ALEX AVENUE PUBLIC SCHOOL

SSD RESPONSE TO SUBMISSIONS

Department of Education. — 8th August 2019

1 FARMLAND DRIVE STREETSCAPE ELEVATION
1:300

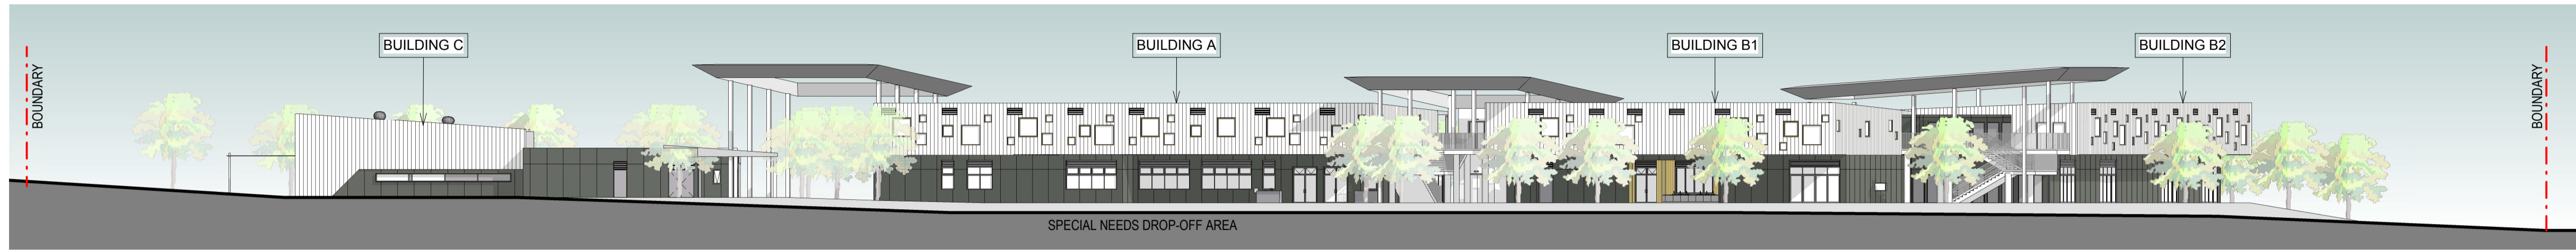
The relationship between the hall and Farmland Drive is a large blank façade with only a couple of small door openings. This façade should be further articulated to create an engaging, welcoming interface with the street.

The facade of the hall facing Farmland Drive is small in scale and is not considered a 'large blank facade'. The facade is broken up with materiality

The Farmland drive curtilage to the Hall houses the site substation and Pump room for authority access. The locations of these services is limited due to the current extent of Farmland drive and minimal street frontage.

The opportunity for the hall to engage with the street has been opened up to the 'Plaza' whereby the active frontage of the school to the adjacent community parklands provides an engaging and welcoming interface.
